From: Barry Stowe <barrys@opechee.com>
To: 'Jean Fraser' <JF@portlandmaine.gov>
CC: Steve Long <stevel@opechee.com>, Jason Blais <jasonb@opechee.com>
Date: 1/15/2013 2:33 PM
Subject: RE: Site Plan (CO4) RE: JB Brown
Attachments: Revised Project Data Marriott Portland 01-15-13.pdf; Lighting Specs Marriott Portland 01-15-13.pdf; Highland Stone Retaining Wall Marriott Portland 01-15-13.pdf; C10 Construction Details Marriott Portland 01-15-13.pdf; C00 Cover Sheet Marriott Portland 01-15-13.pdf; C02 Existing Conditions Marriott Portland 01-15-13.pdf; C03 Demolition Plan Marriott Portland 01-15-13.pdf; C04 Site Plan Marriott Portland 01-15-13.pdf; C09 Photometrics Plan Marriott Portland 01-15-13.pdf; C08 Landscaping Plan Marriott Portland 01-15-13.pdf

Subject: Site Plan (CO4) RE: JB Brown

DATE: 10-22-12
SCALE: 1"=20"
DRAWN BY: BJS
C11
SHEET: 11 OF 14

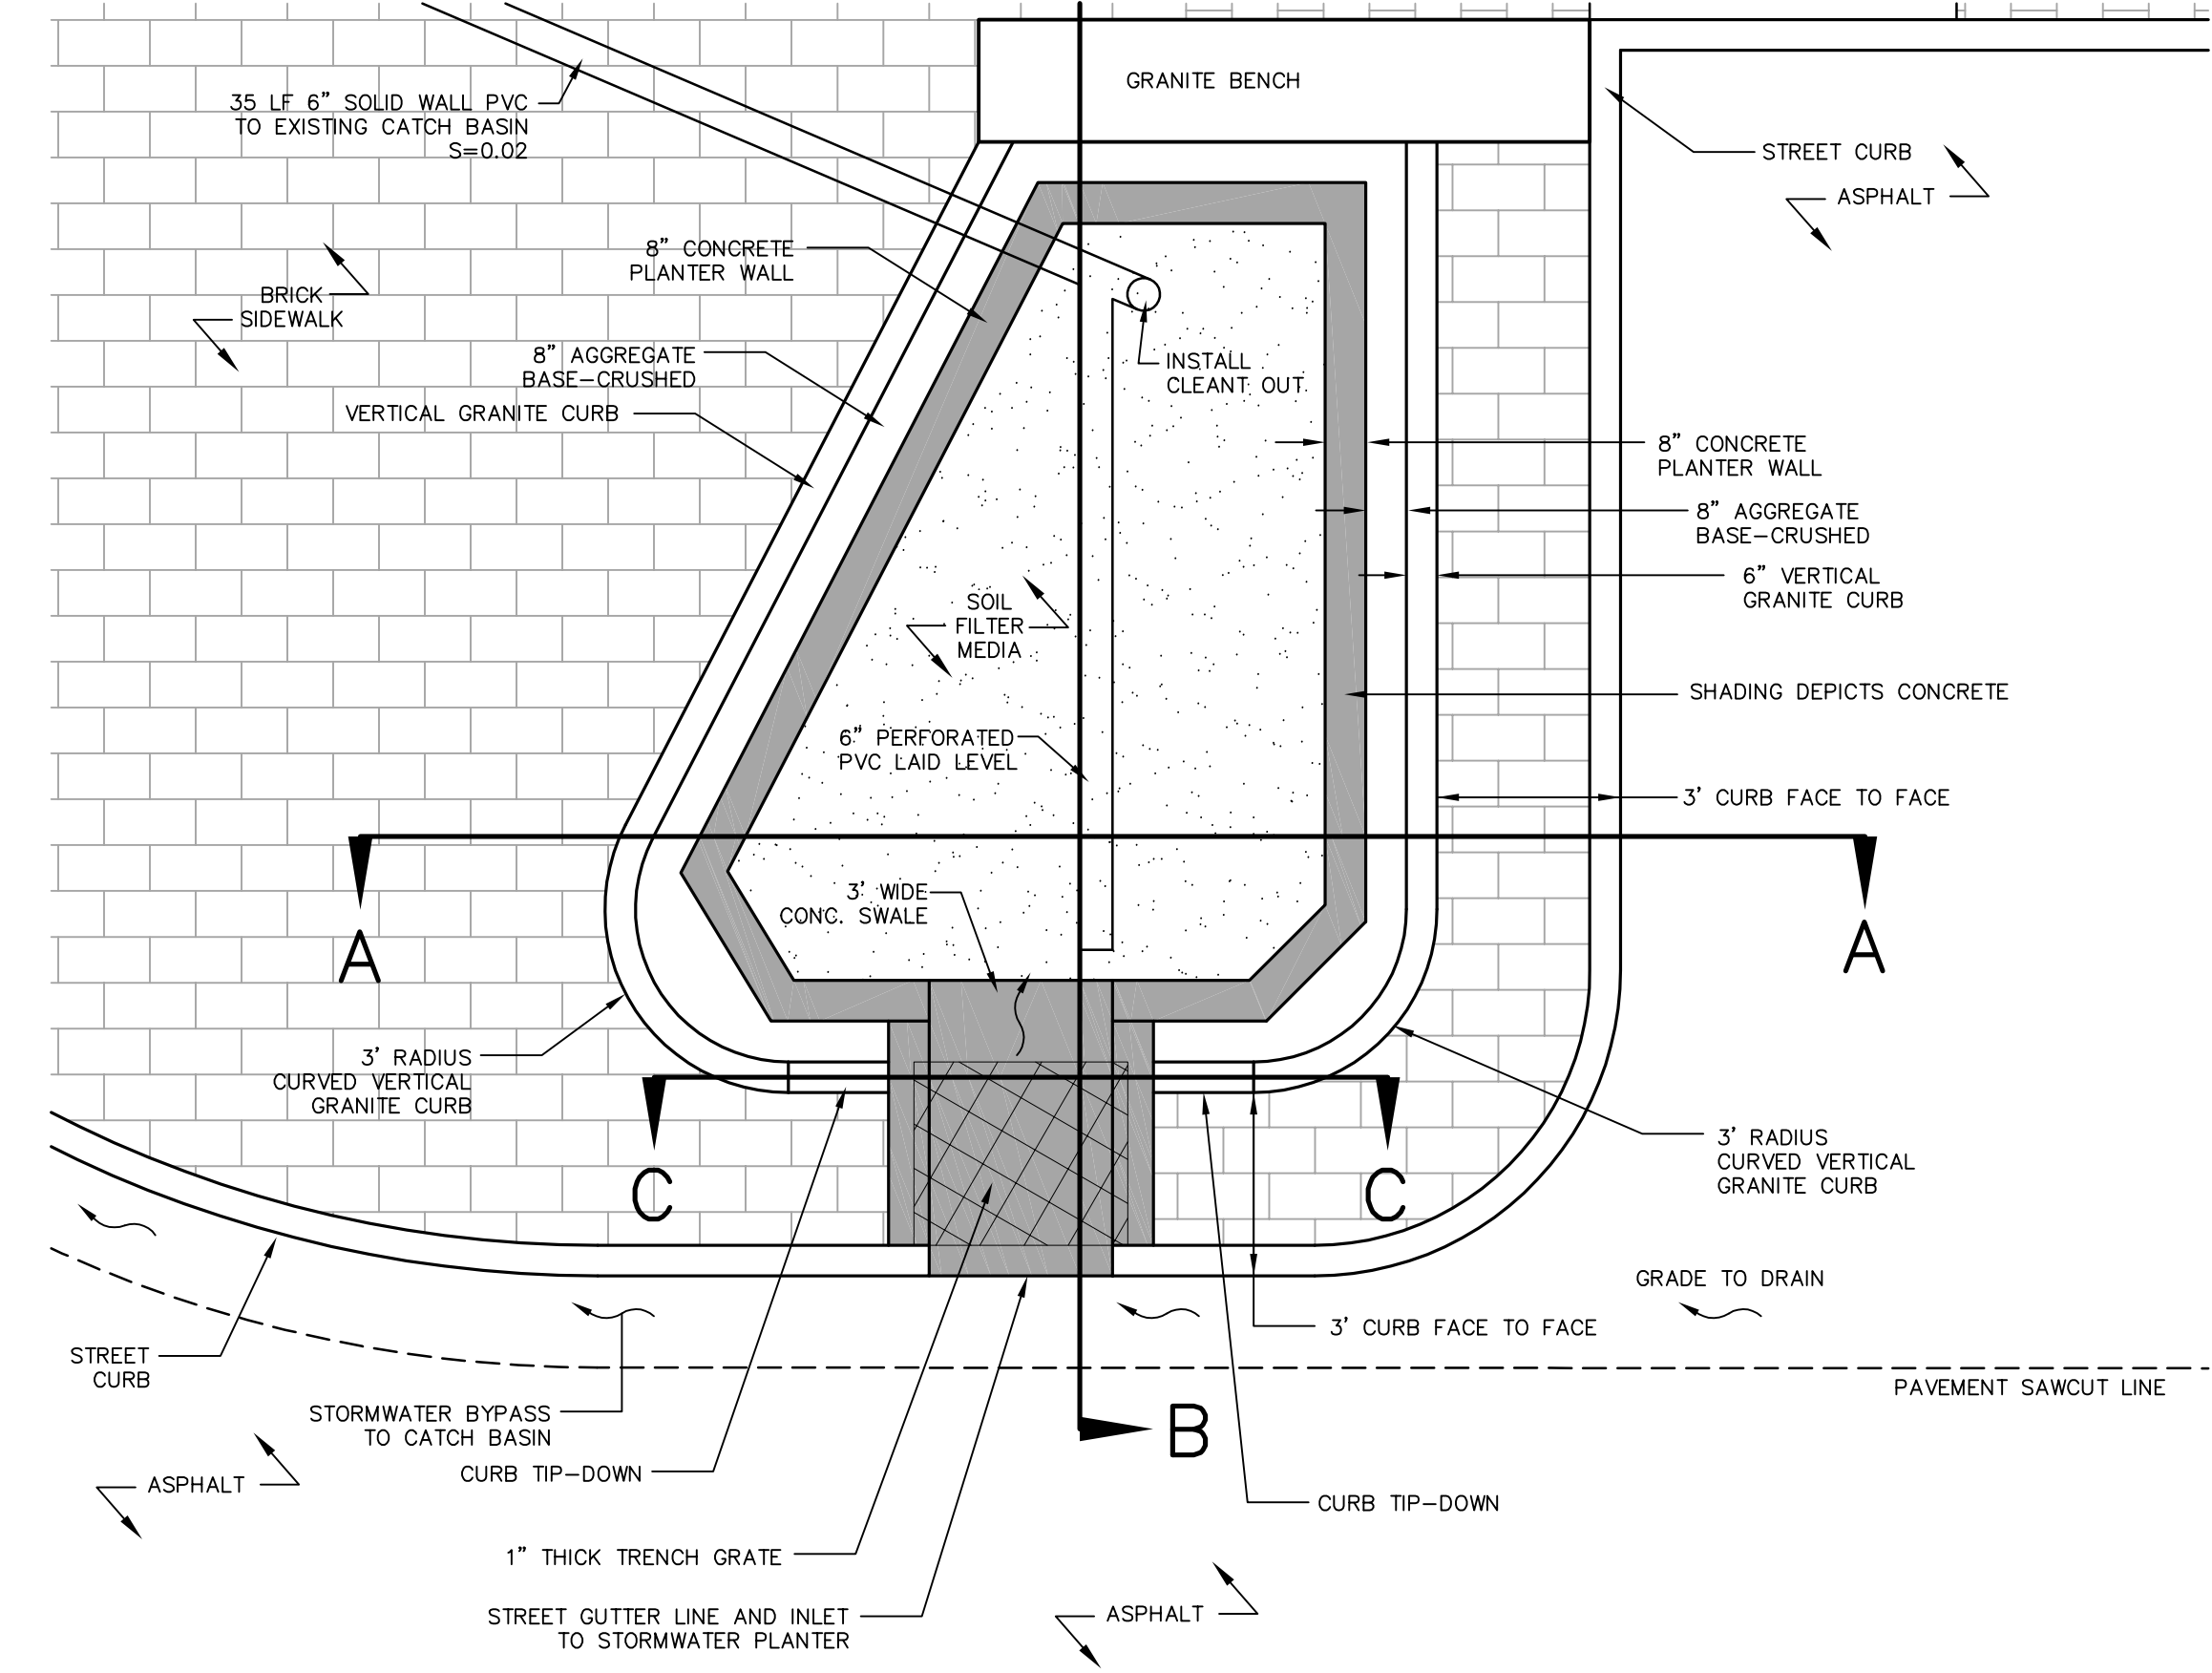
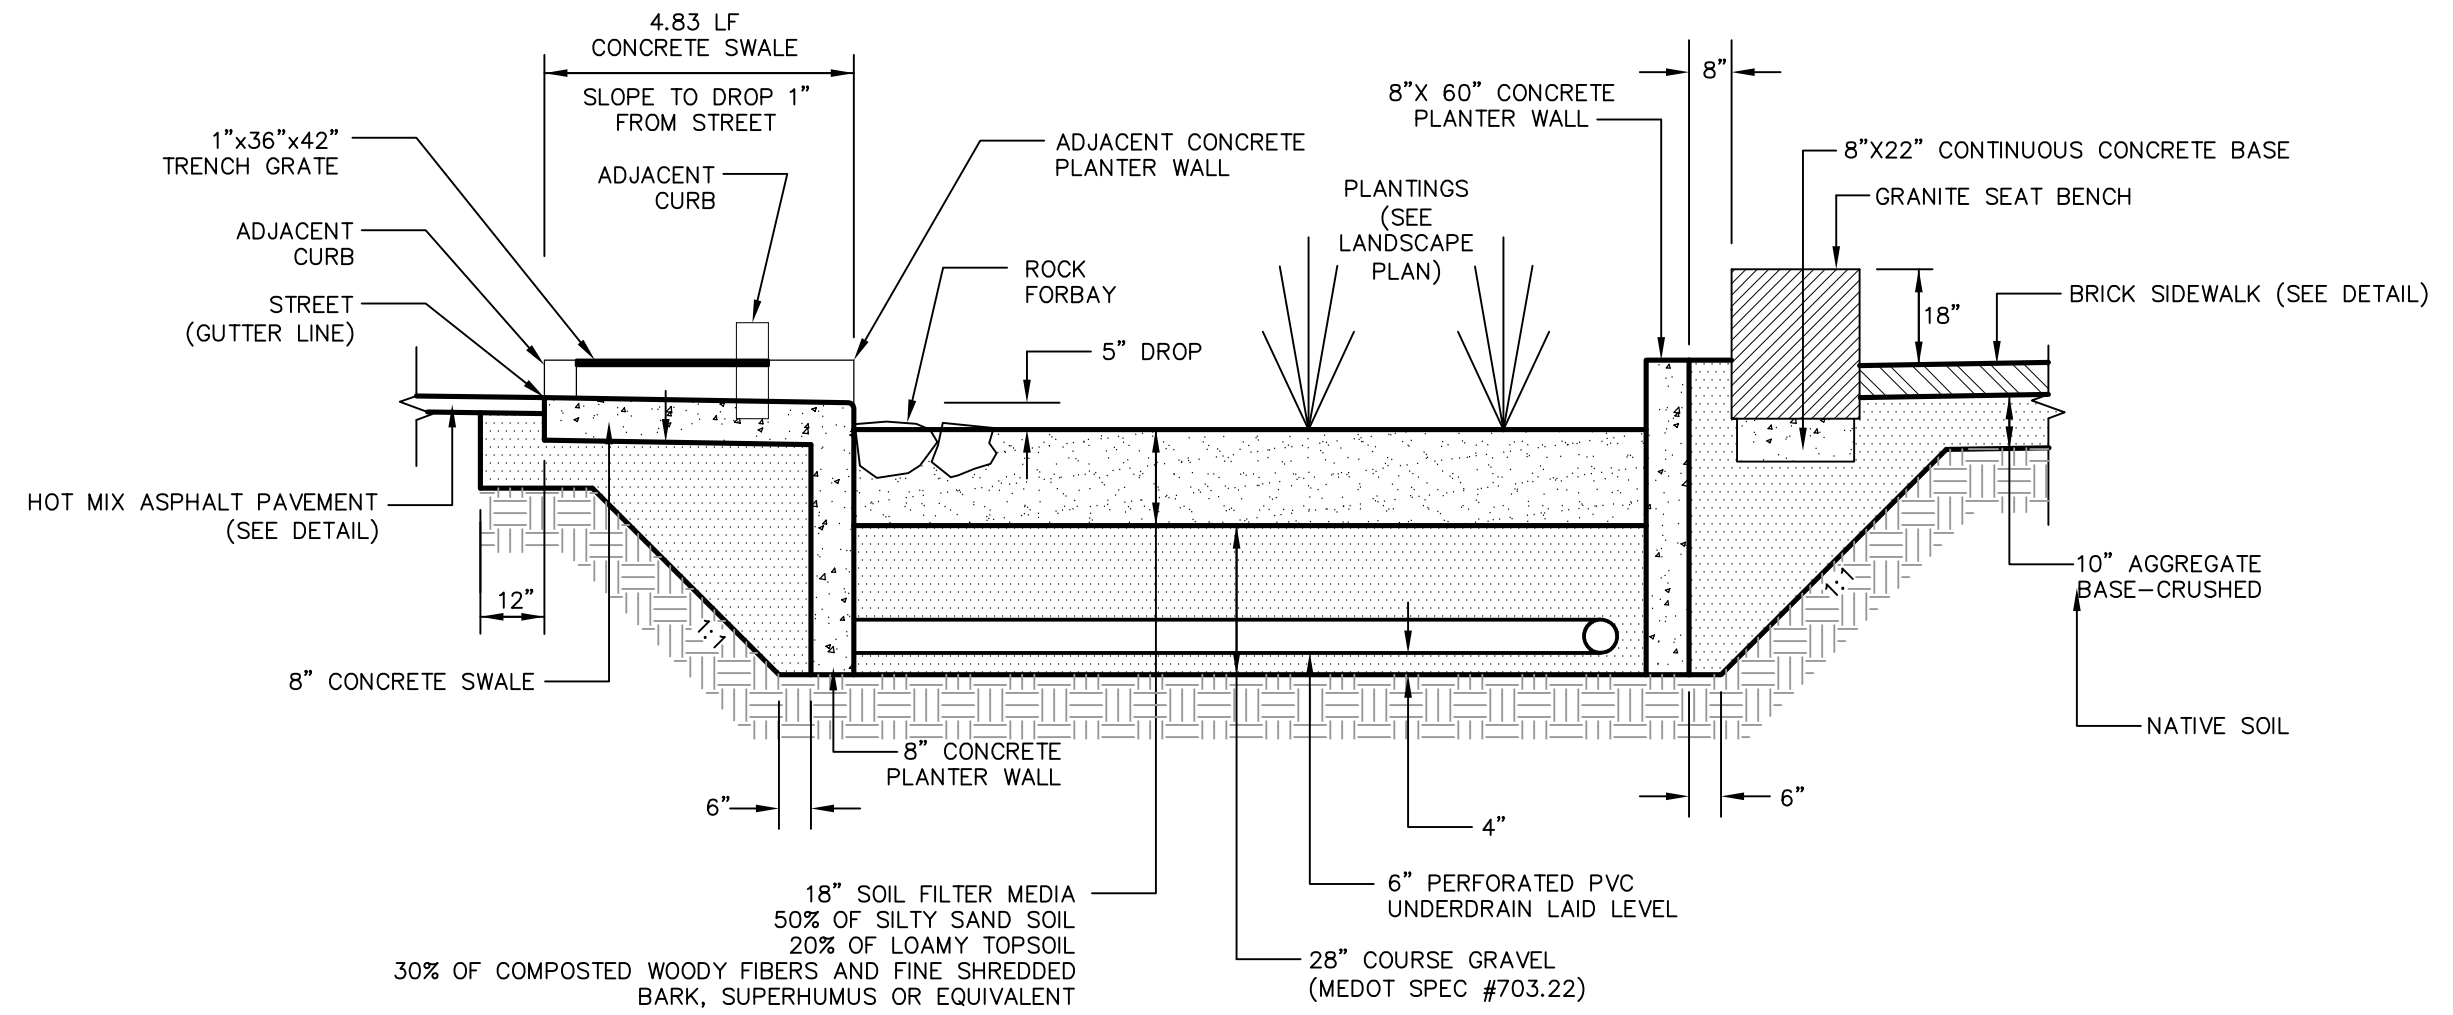
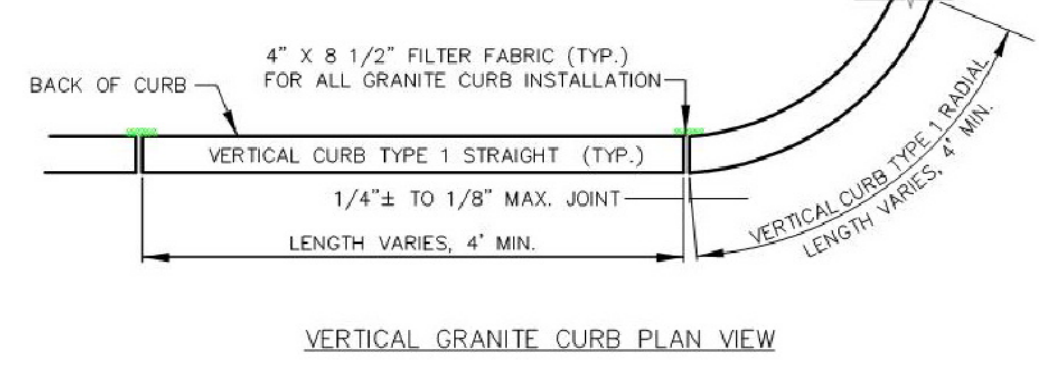
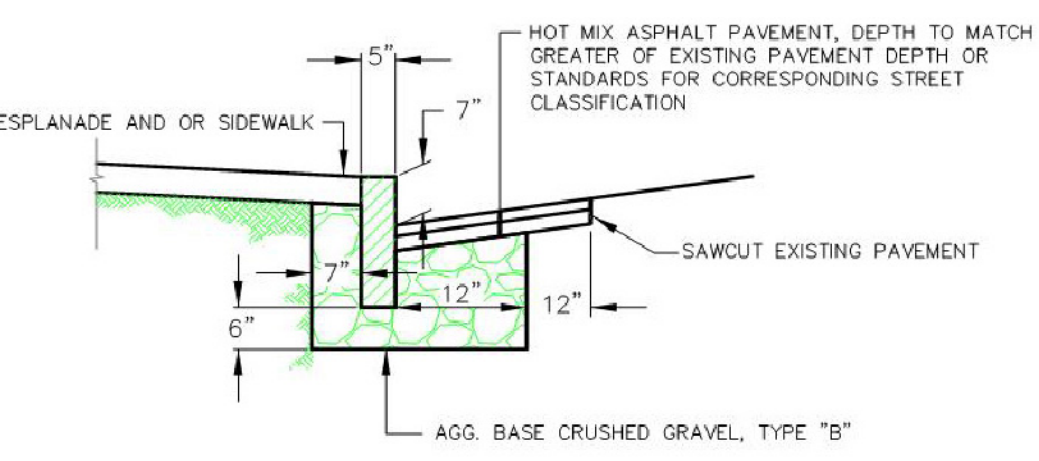
- Added wall sconces
 - Moved light pole near transformer
 - Changed grid to 5'x5'
- C10 Construction Details
 - Deleted previous retaining wall section and added the new wall section.

7. Parking spaces- consider additional bollards to stop cars parking across the flush granite curb and too near to wall of the building
8. Planter in sidewalk "bump-out" near hotel entrance needs raised curb- I will get back to you on this after I hear from the City Arborist

8. Planter in sidewalk "bump-out" near hotel entrance needs raised curb- I will get back to you on this after I hear from the City Arborist
The planter has been revised to have a raised vertical granite curb.
